**FFERM WYNT ALLTRAETH MONA / PROPOSED MONA OFFSHORE WINDFARM**

**CYFEIRNOD YR AROLYGIAETH GYNLLUNIO / PLANNING INSPECTORATE  
REFERECE: EN010137**

**RE: NATURAL RESOURCES WALES' DEADLINE 2 SUBMISSIONS**

Figure 1.2: Black-legged kittiwake expected collisions across per months, contrasting a 0.9928 avoidance rate (NE) with a 0.9979 rate (Ozanlav-Harris et al).

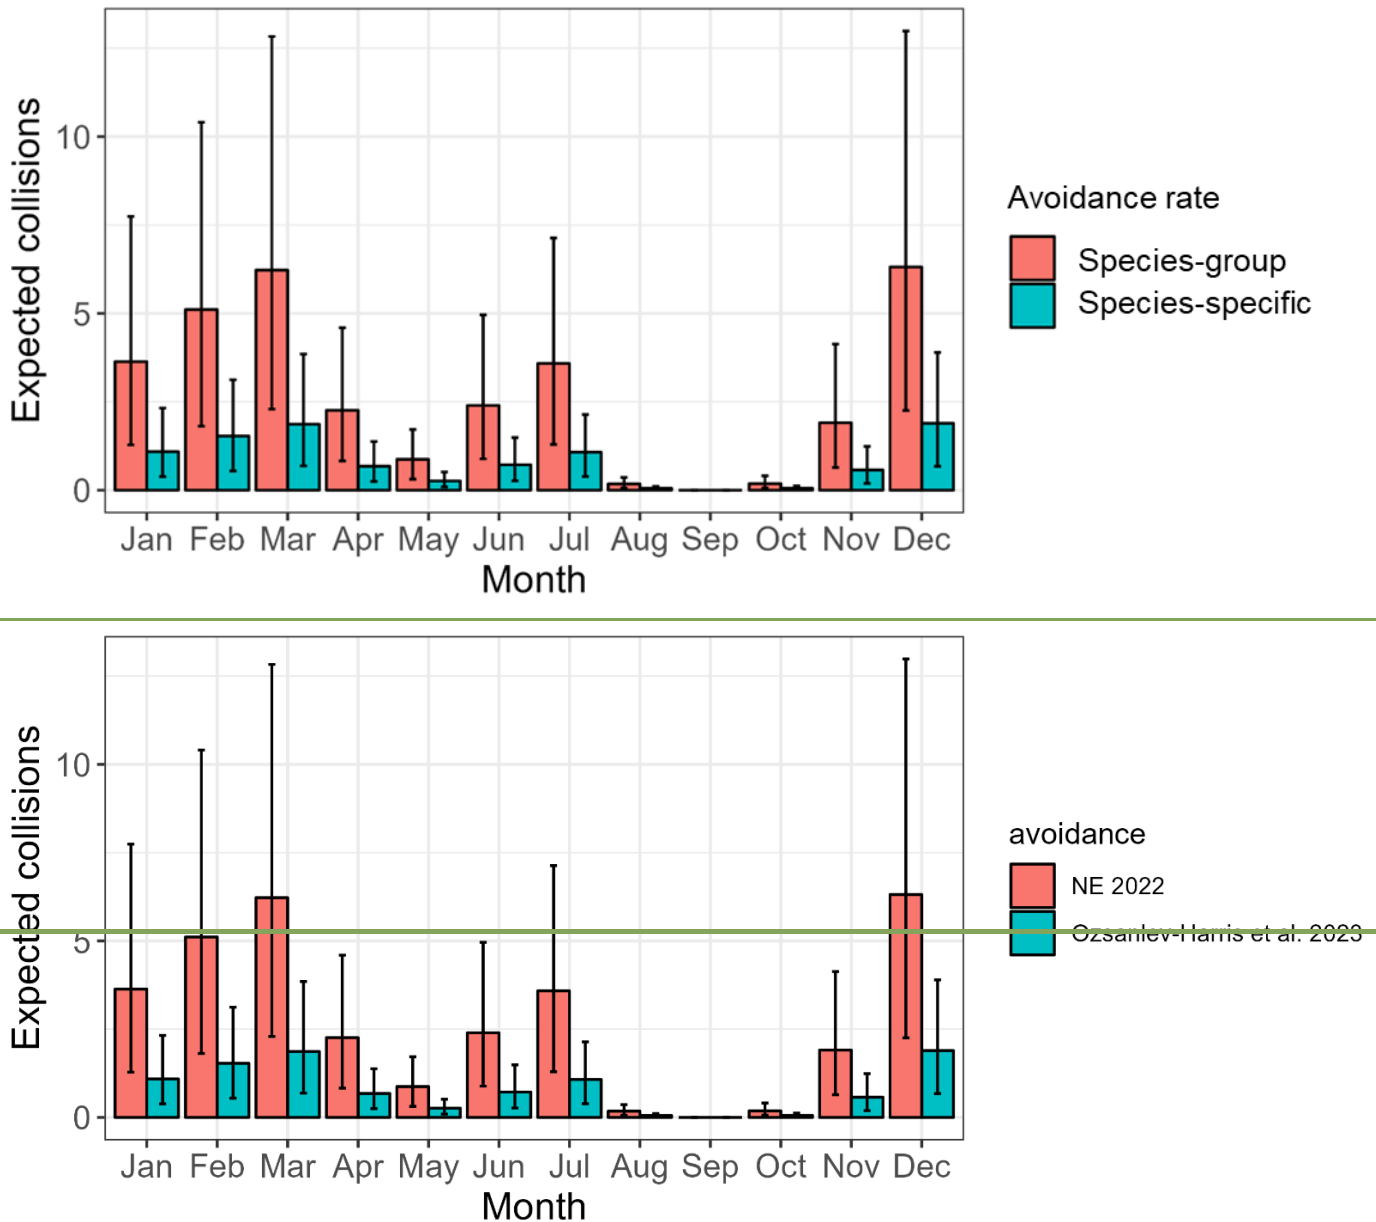
In PDA-008, the Applicant's response to Relevant Representations (specifically response to reference RR-011.3), the Applicant has indicated that they have taken an approach for kittiwake collision of splitting in half the monthly collision estimates for April and August and applying these across two seasons (April: half in pre-breeding/spring migration and half in the breeding season; August: half in breeding season and half in post-breeding/autumn migration). From the results presented in Table 1-2 of REP1-037 it appears that this approach has again been taken in the assessment of kittiwake collision to Pen y Gogarth / Great Orme's Head SSSI. However, clarification is required from the Applicant as to whether this is the case. If this approach has been taken, as noted in our Written Representations [REP1-056], this approach of splitting monthly collision impacts across two different seasons was not discussed during the EWG and it is unclear why the months above have been split across seasons for kittiwake as from Table 5.14 of the Offshore Ornithology Chapter [APP-057], the seasonal definitions for this species do not have any months where part falls in one season and another in another season. Furness (2015) defines the full breeding season for kittiwake as March-August, we would advise this definition is used and then adjusting the non-breeding season definitions in Furness (2015) accordingly to ensure no months are considered in two seasons. If the approach of splitting collision estimates from one month across multiple seasons has been taken in this assessment, then we advise the Applicant

reconsiders its EIA seasonal collision predictions for kittiwake and hence any apportioned collision impacts to the SSSI (as per our advice in our Written Representations, REP1-056).
